Development Facilitation Team (DFT) – Review Comments

DRB Project No: PR-2019-002677 Date: 6/14/2023 Agenda Item: 5 Zone Atlas Page: H-17

Location: 2100 Carlisle Blvd NE

Application For: SD-2023-00111 – VACATION OF PUBLIC EASEMENT

THIS SHEET SHOWS EXISTING IMPROVEMENTS WITH DEDICATION, EASEMENTS, AND VACATED EASEMENTS.

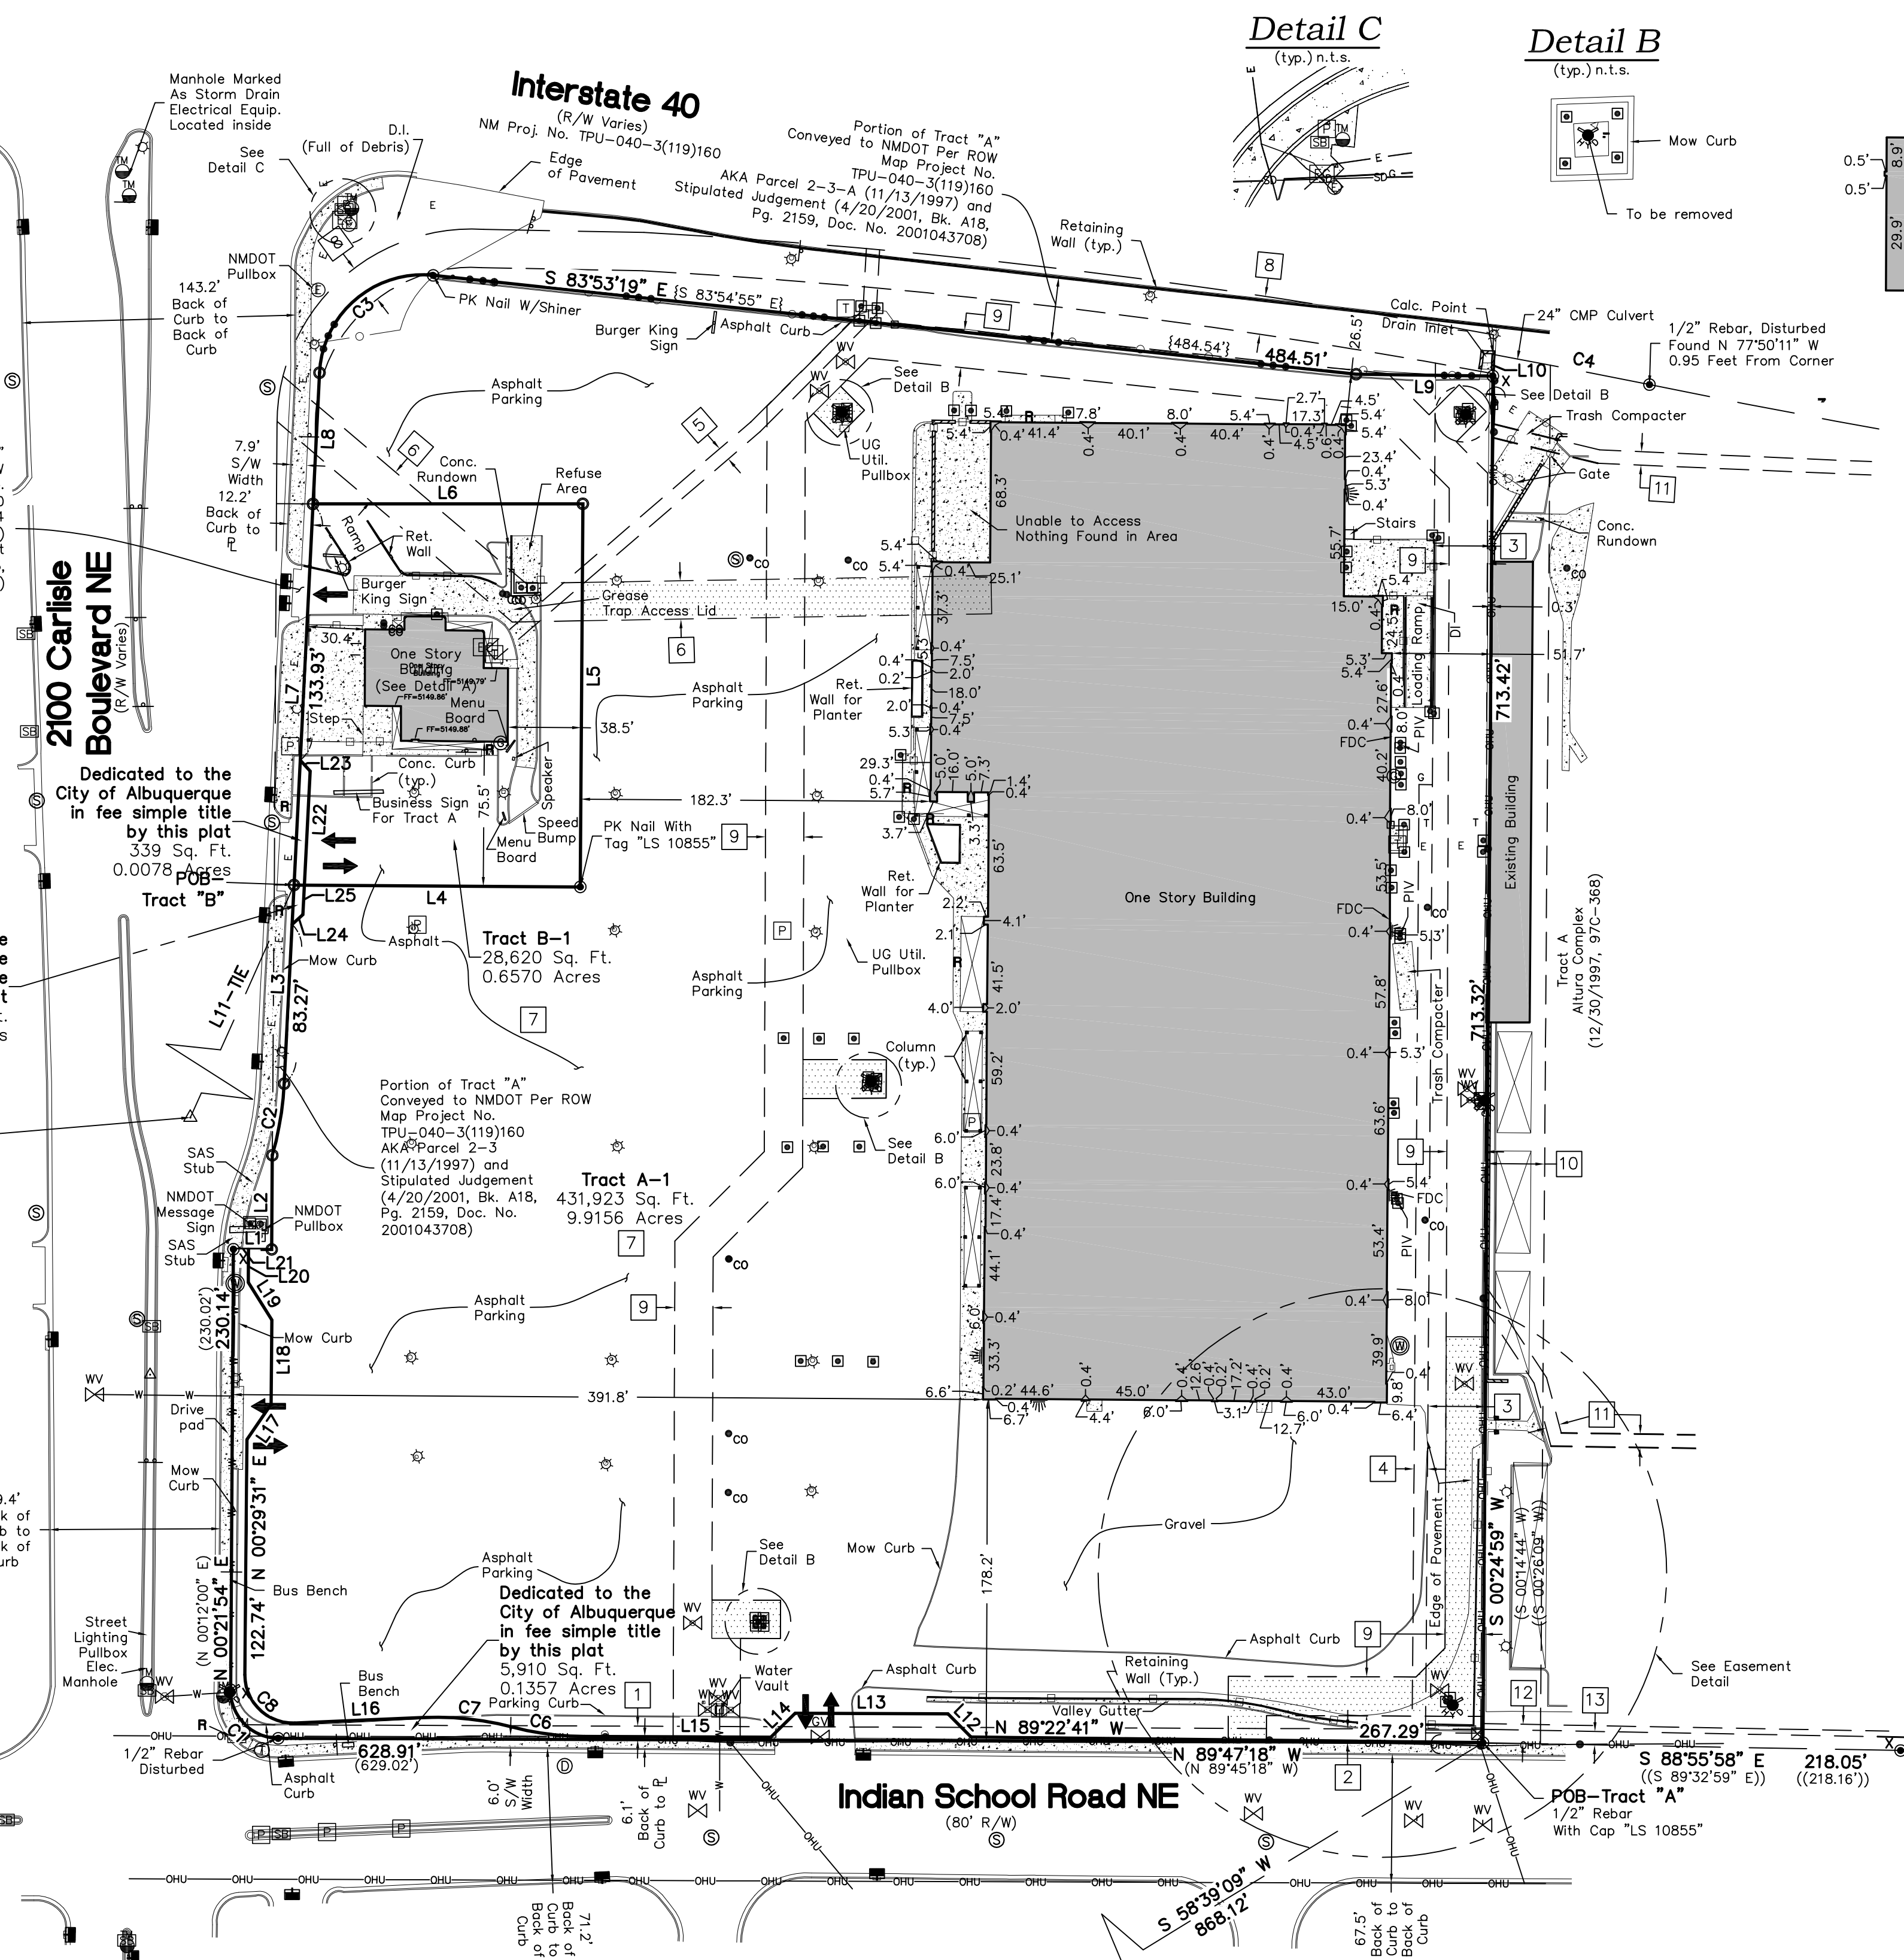
1. No objection however, please confirm the proposed Tract B1A has a service that does not require any of easement 16 proposed to be removed.
